Our ref: RA/2024/147770/04-L01
Your ref: 2024/91476

Date: 28 February 2025

ERECTION OF 24 DWELLINGS – CLOUGH FARM, LONG LANE, EARLSHEATON, DEWSBURY, WF12 8LQ

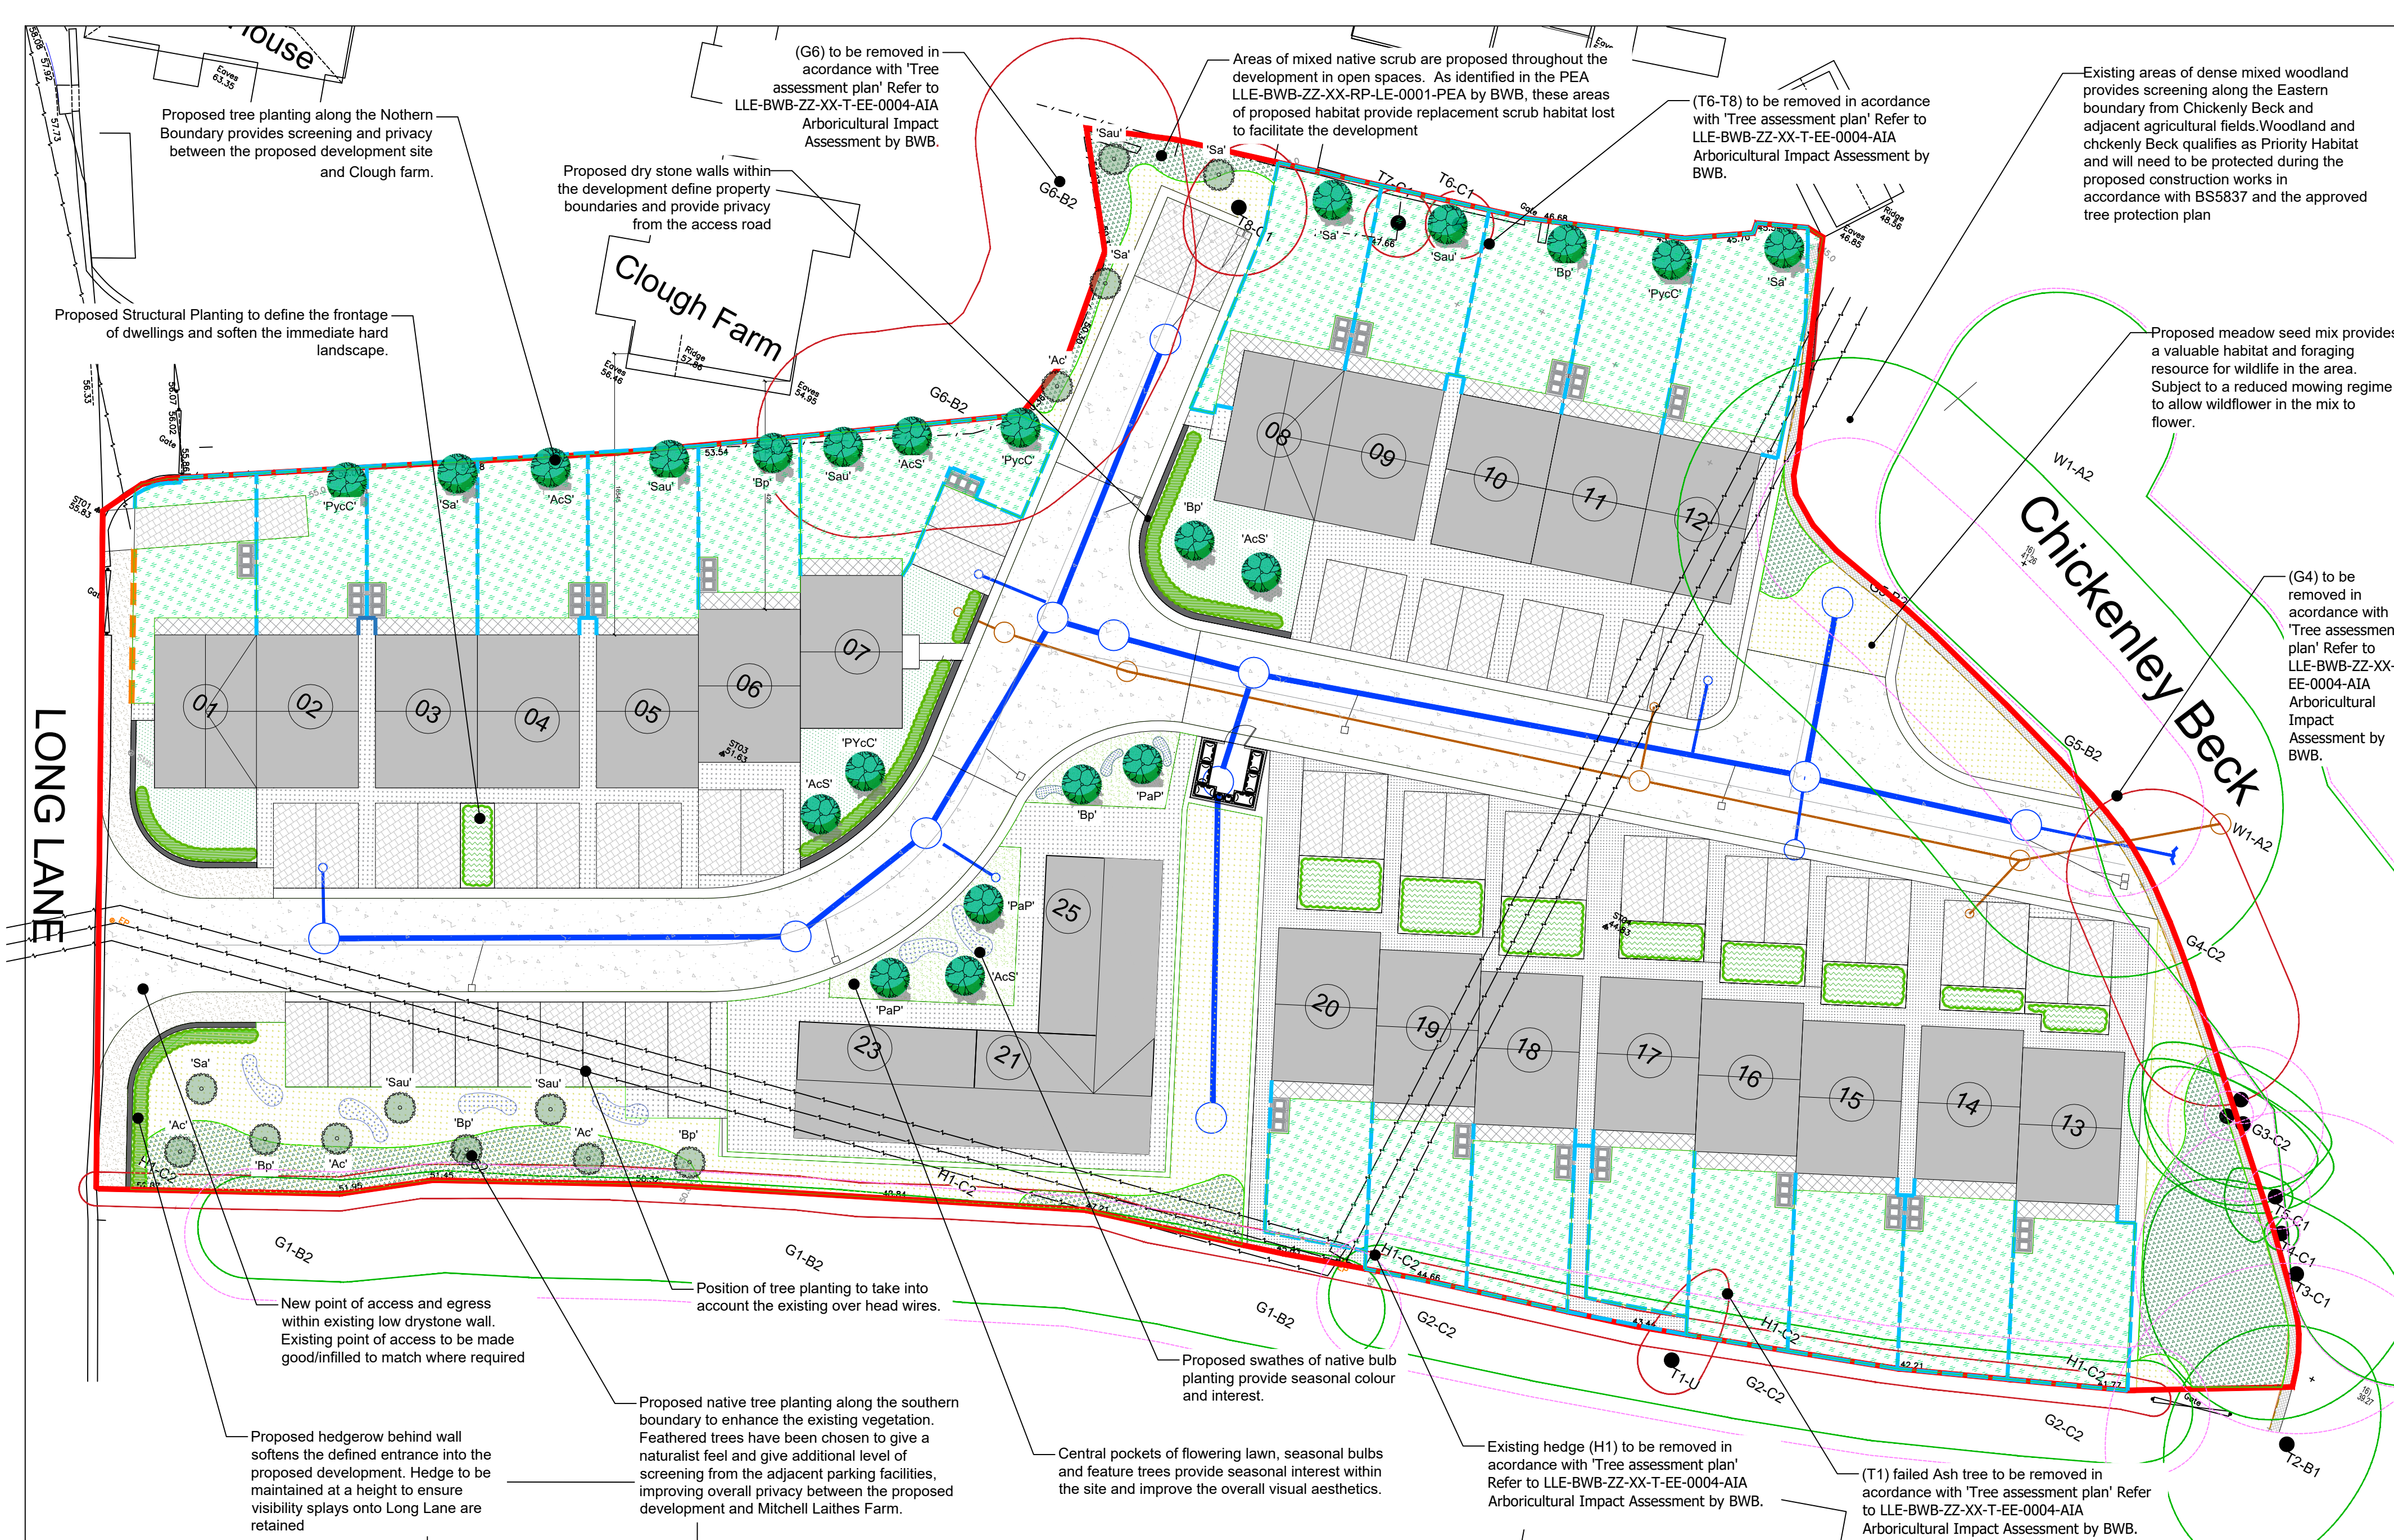
We can see that the site layout has been altered in the new plan shown in the document titled published on the planning file as "Proposed Site / Block Layout [jd 1075522] Size: 479KB 07/02/2025 - Site Plan Rev L." However, the areas of hard development (block 12, non-adopted highway, block 13) that encroach into the riparian corridor have not been set back from the watercourse and remain the same as the original layout with the addition of two parking spaces. Instead, the areas of soft landscaping such as meadow seeding and scrub planting along the edge of block 13 and 12 and by the access road have been removed from the plan.

The change to the red line boundary and layout of the new plan has resulted in loss of soft landscaping and does not look like it has reduced the quantity of hard surfaces in the riparian corridor. This is not what we intended to achieve in our original response when we requested a 10m buffer zone.

We understand that a 10m buffer may not be possible across the whole boundary of the site. We ask that the applicant uploads an updated landscape masterplan to show how soft landscaping will be incorporated into the riparian corridor.
